**Subject:** FW: H191 RE: 6842\_170314\_Oshwal Centre\_rear extension\_final solution\_01\_fr  
paolo\_6842\_C7

6/2016/0995/FULL

DRAWING TITLE
**OSHWAL HOUSE REAR
 EXTENSION-EXISTING AND PROPOSED
 ELEVATIONS**

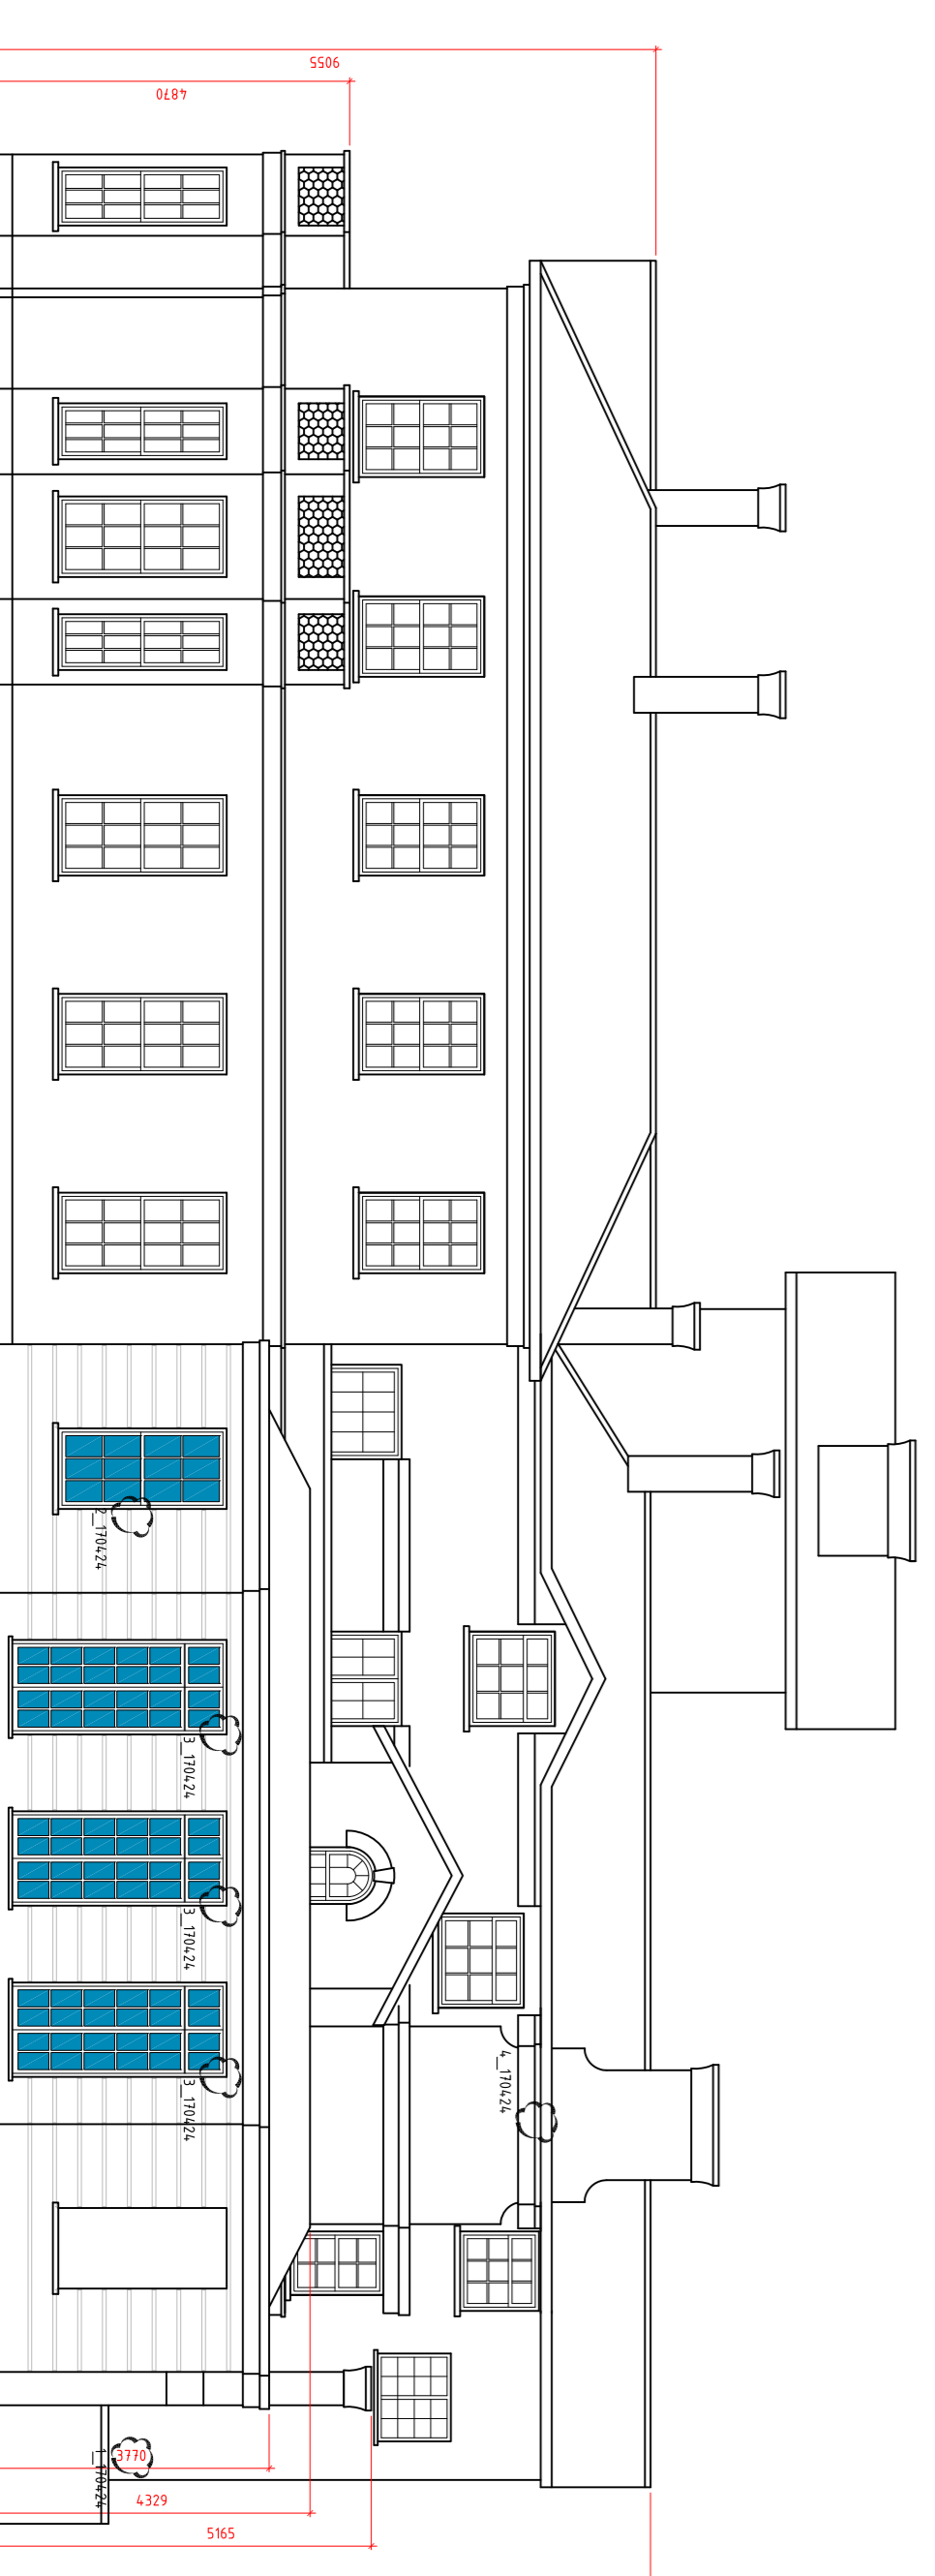
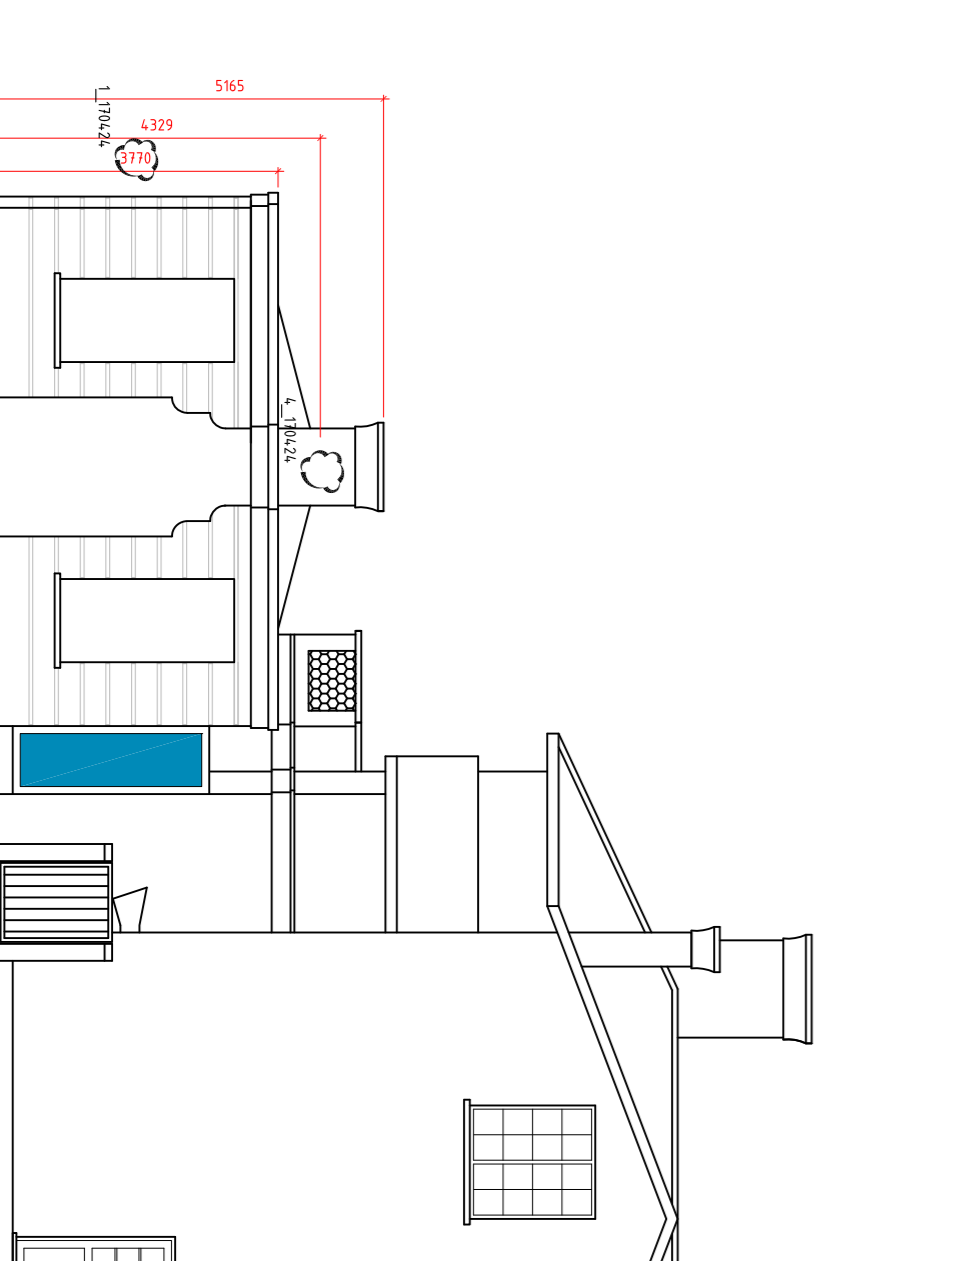
As I hinted, the glazing bars for the French doors may have to be modified because it is unlikely that the number of panes shown would fit in without becoming too fussy. However we could control this by specific conditions.

Notwithstanding the approved drawings, the glazing pattern of the French doors should be re-considered as part of the above condition
